DECISION DELEGATED TO DEVELOPMENT MANAGER
--

Application No:	H21-0478-20	Applicant:	Mr A Barker
Proposal:	Proposed 2 metre high boundary fence		
Location:	5 Kiln Drive Tydd St Mary Spalding		
Terminal Date:	13th October 2020

5 kiln drive

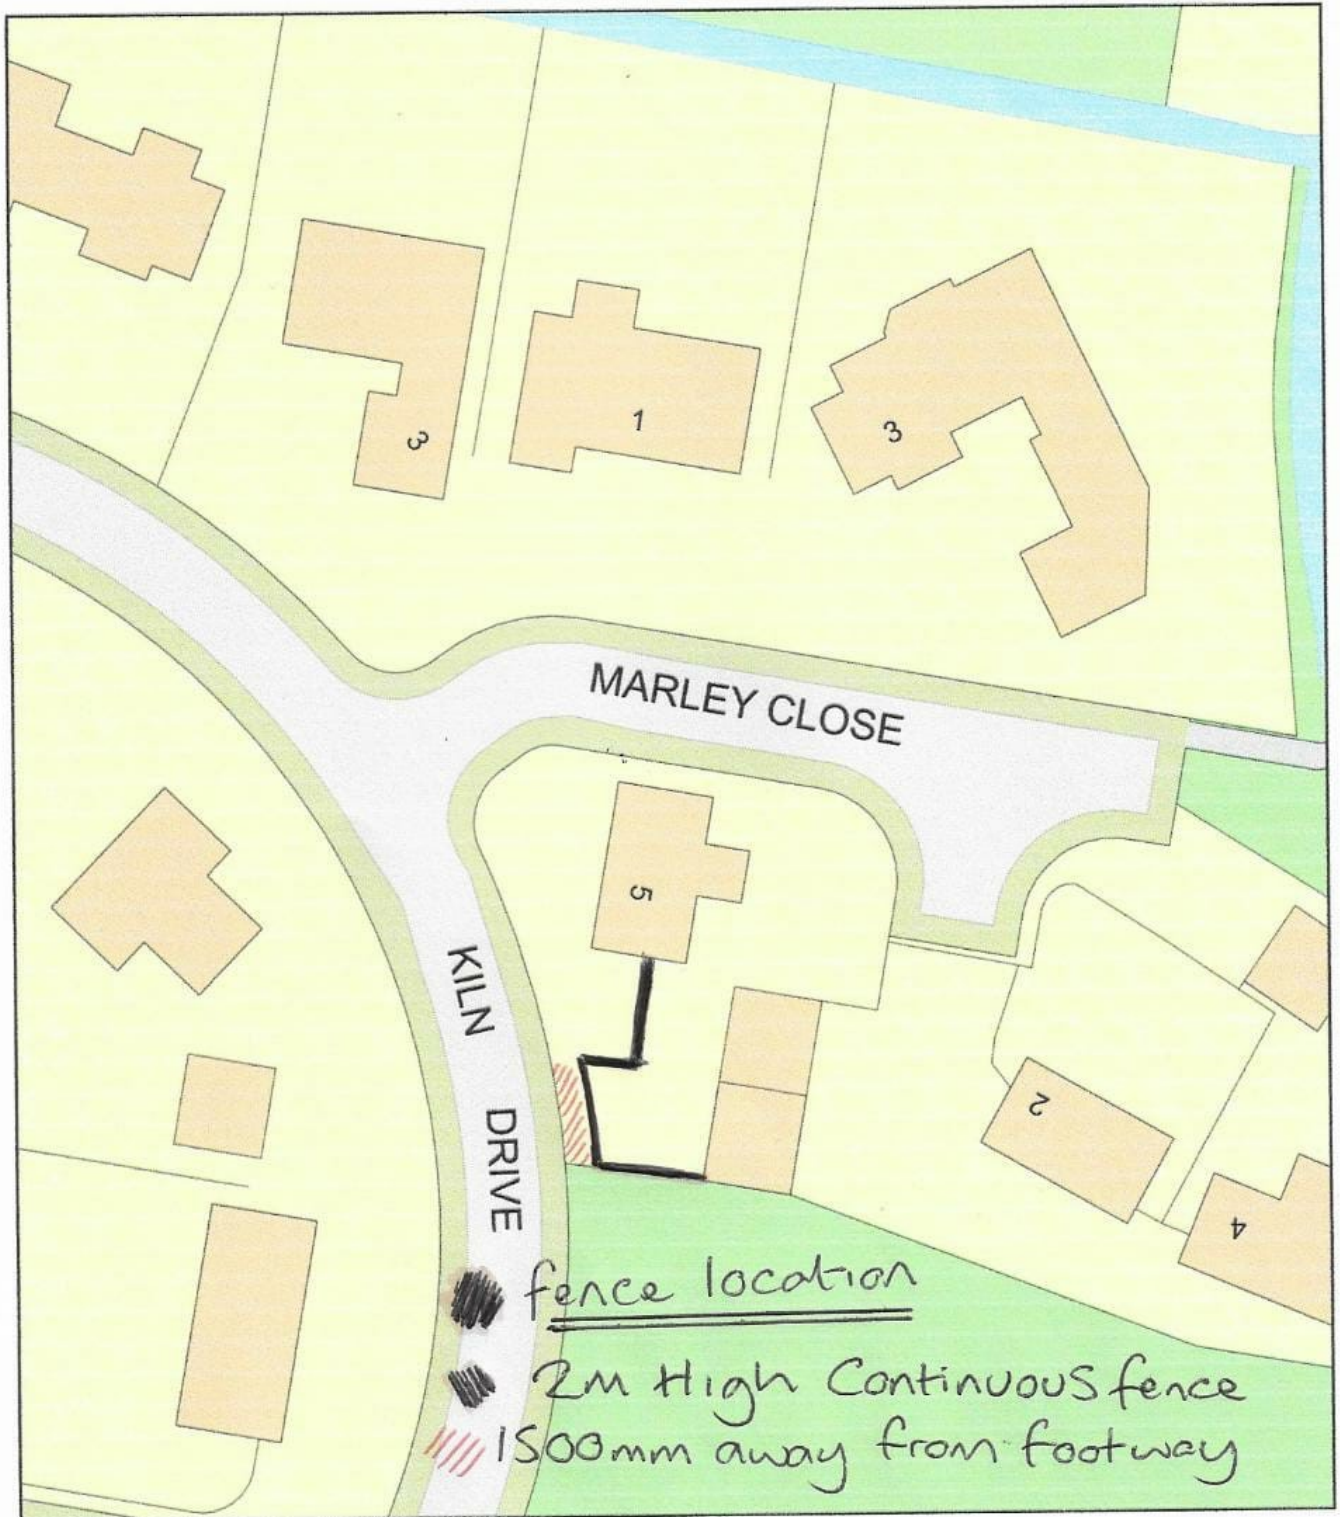
A revised block plan was submitted in order to clarify the details of the proposals and dissipate LCC Highways Authority concerns.

southern site boundary. The position of the fencing will be irregular. The first metres will split the driveway into two different parts. The remaining part to the highway will have depths ranging approximately between 7 and 5.50 metres. After running to the front of the garage doors, the fence will be in closer proximity to the highway keeping a distance of roughly 1.5 metres from the edge of the footpath. Then, the mean of enclosure will run backwards in parallel with the southern boundary of the site.

In summary, the appearance and height of the proposed fence will be acceptable given the site layout and residential nature of the property and its surroundings. The irregular position will entail that part of the fence will be clearly visible from the road but a separation distance of 1.5 metre from the edge of the footpath will prevent any unacceptable harm upon the street scene which will lead to refuse this application. Overall, the development meets the functional needs of the house occupiers. For these reasons, on balance the proposed fence will comply the criteria of the aforementioned policies concerned on design and layout.

A revised block plan was submitted following discussion with LCC Highways Authority and the applicant. To prevent any reduced visibility for the drivers of cars egressing the vehicles from the driveway, the nearest part of the fencing was set back 1.5 metres from the highway. LCC Highways Authority has raised no objection to the amended proposal.
